From: Adrian Dowd
Sent: 07 November 2012 15:45
To: Jane Tucker
Subject: FW: Consultation on planning application 3/2012/0589 Greengore Farm, Hill Lane, Hurst Green

From: Hornby, Mark [mailto:Mark.Hornby@lancashire.gov.uk]
Sent: 07 November 2012 15:43
To: Adrian Dowd
Subject: FW: Consultation on planning application 3/2012/0589 Greengore Farm, Hill Lane, Hurst Green

This proposal for two and four bedroom barn conversions respectively would not generate significant additional traffic to the site. Access from Shire Lane is via Hill Lane, a 1.2km single track private road with a tarmac surface as far as Hill Farm and a good quality stone surface thereafter to Greengore Farm. There are three passing places along the length of Hill Lane which I would consider adequate for the likely levels of traffic. The two barn conversions appear to have adequate parking and turning space provided within the curtilage.

Drawing:
Site Location Plan

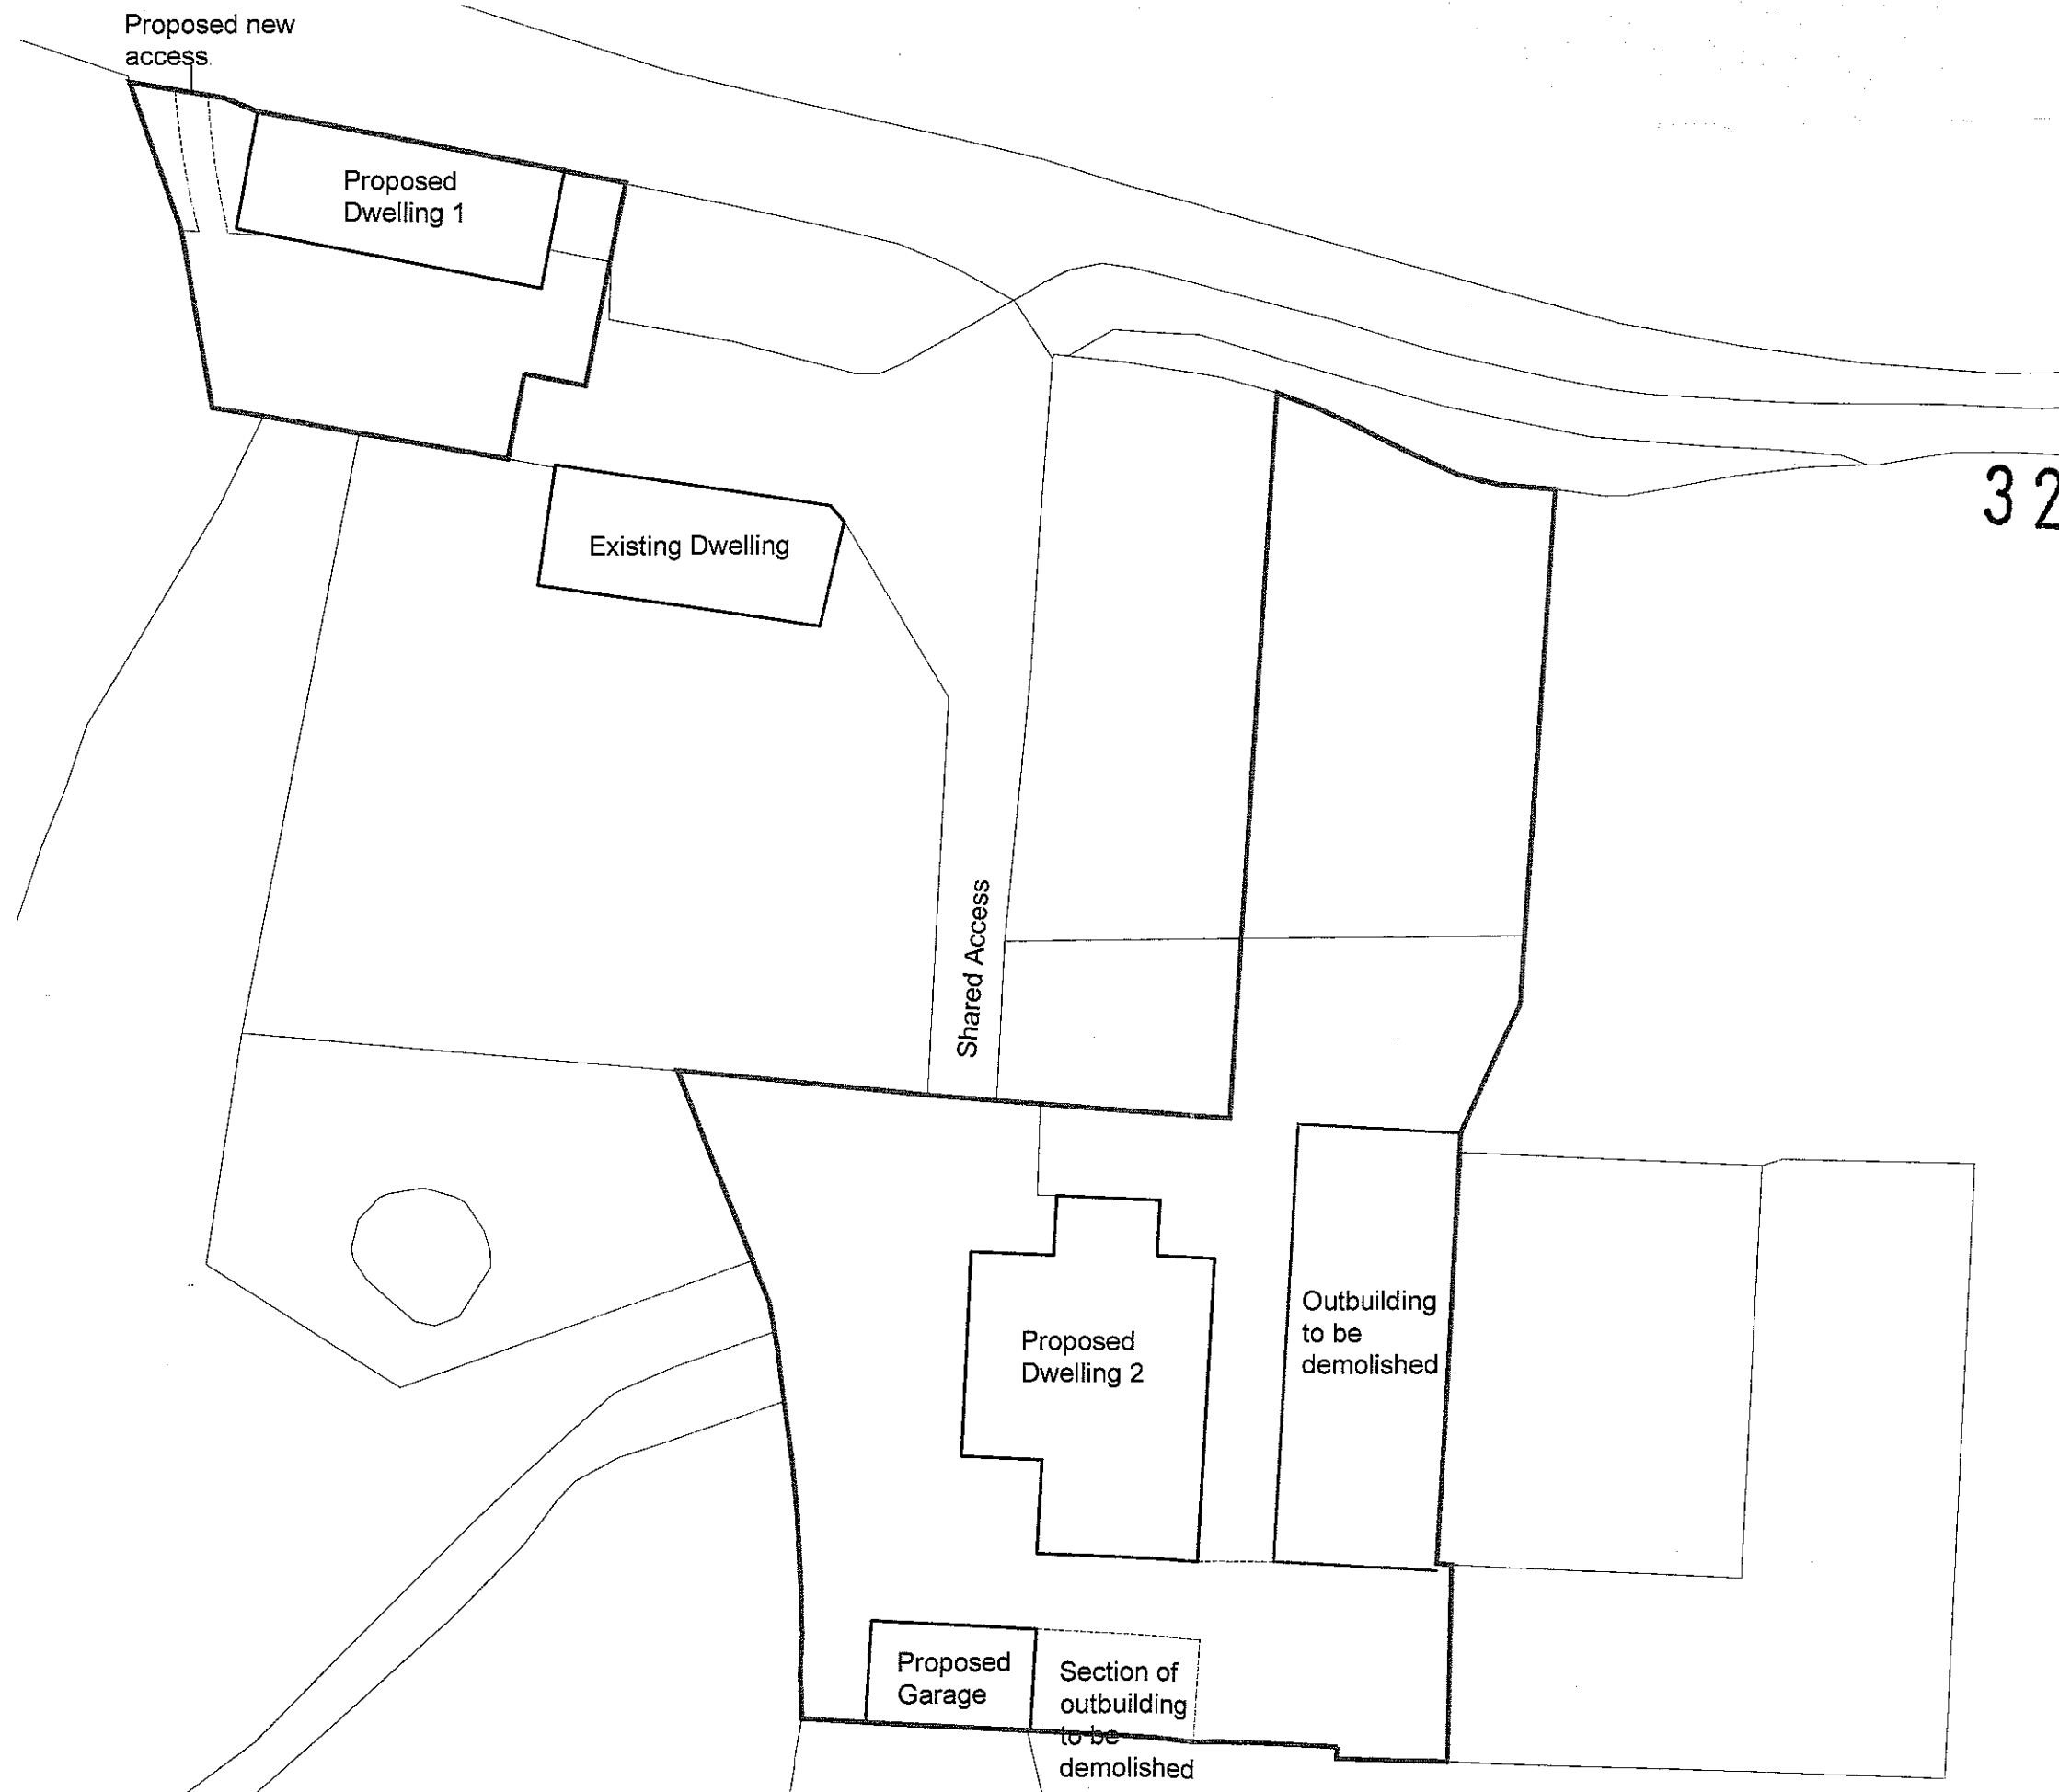
I therefore have no objection to this proposal.
